The Coal
Authority

Re: Planning Application 2024/62/93474/W

Change of use from vacant industrial unit to 21 flats / maisonettes including partial demolition and new build; 35 St John's Road, Birkby, Huddersfield, HD1 5DX

The Coal Authority response: **Fundamental Concern**

client	MR H CHAHAL		
project	RESIDENTIAL DEVELOPMENT 35 ST JOHNS ROAD BIRKBY HUDDERSFIELD HD1 5DX		
drawing	PROPOSED FLOOR PLANS		
revision	notes	date	drawn
scale :	1:100 AT A1	11.24	PB
project no.	2327	drawing no.	03

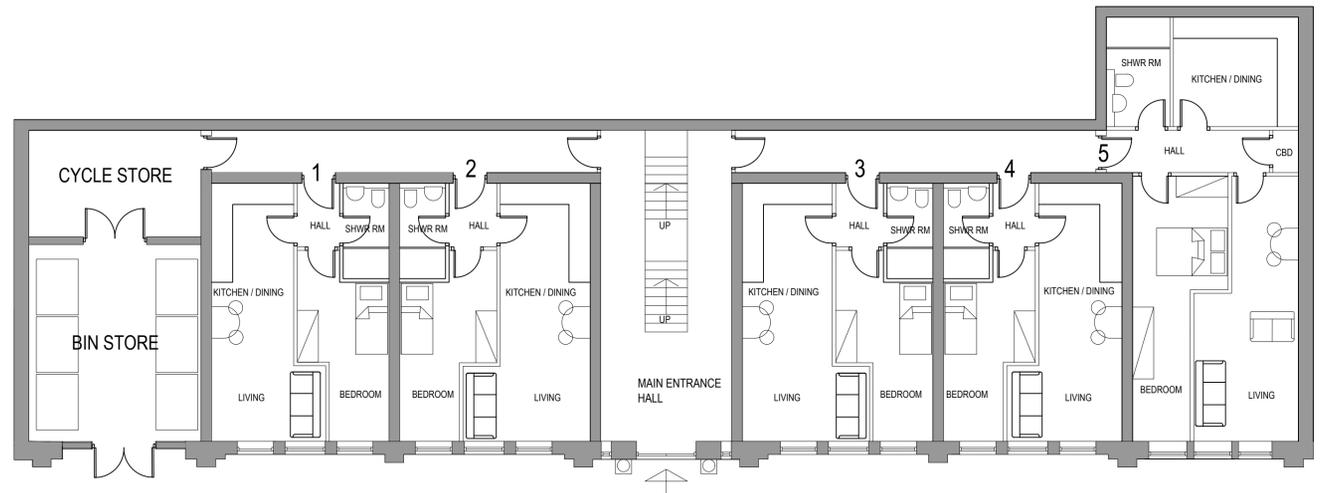
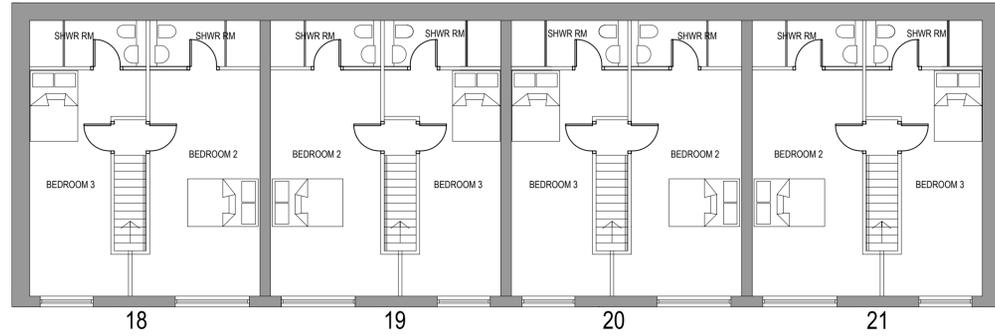
In this instance, it appears that proposed plots 18 and 19 and the new courtyard/garden area may be sited directly above mine adit 414417-001, with its associated potential zone of influence encroaching beneath the part of the existing building to be retained. As such we would expect a plan to show the position of the mine adit feature and its departure distance in the context of the specific scheme of development to be provided.

The Planning team acknowledges that there already exists a building above the plotted position of the adit and, as such, it may have already been built over. Nevertheless, we would expect justification to be provided by the applicant as to why the adit feature cannot be avoided within the detailed layout of the proposed scheme.

Where layouts cannot be amended, for example where operational reasons dictate otherwise or sites are constrained, the development proposal should be supported by a thorough justification for this and a robust engineering strategy, in compliance with CIRIA (C758D), to demonstrate how the development will be made safe and stable. This should include an outline as to how the mine entry will be treated if located and how development will be designed to address its presence.

Site Plan

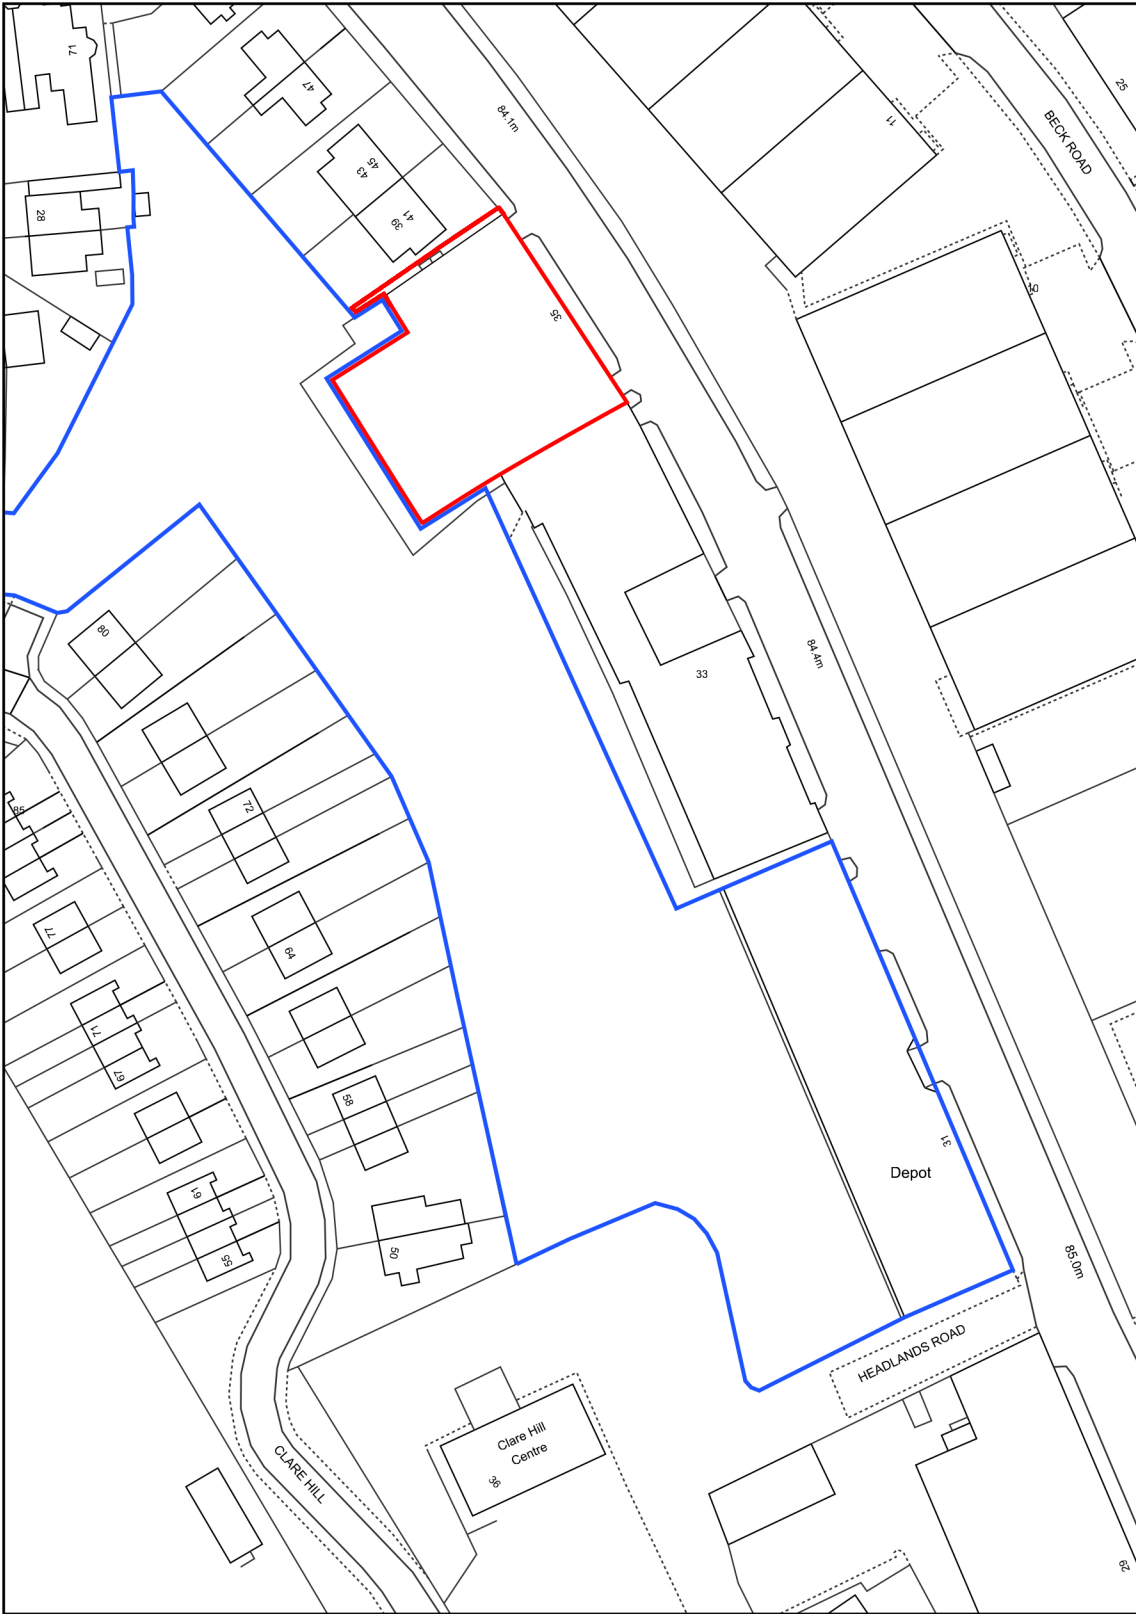
We note that this application is accompanied by a Coal Mining Risk Assessment report prepared by Rogers Geotechnical Services Ltd, dated 28th March 2025. The report has been based upon a review of coal mining and geological information, and identifies that the Soft Bed Coal outcrop, which may have been worked at shallow depth, is present beneath the south west corner of the site and notes the presence of adit 414417-001 in the same part of the site, oriented away from the outcrop and into the hillside.

However, the report author comments that *“given the conjectured position of the adit, it is considered that the mine entry is targeting the Soft Bed coal seam. As such, it is considered unlikely that any workings are present below the site itself as the orientation of the mine entry is away from the site. As such, a low risk has been deemed with respect to the risks to the site from shallow coal workings.”*

In respect of the mine adit the report author details that *“the location of the adit given by the Coal Authority has been given a departure of 10m radius from the given coordinates. As such, whilst the general topography of the area would suggest the adit is most likely set into the hillside, there remains the possibility that the adit is present below the new building footprint. Therefore, a moderate risk rating has been assigned to the site with respect to mine entries.”*

In light of the above the report author has recommended no development should take place without further investigation to conclusively determine the presence and condition of this mine entry (adit). As such they advise that intrusive investigations are undertaken across the site to identify the mine adit.
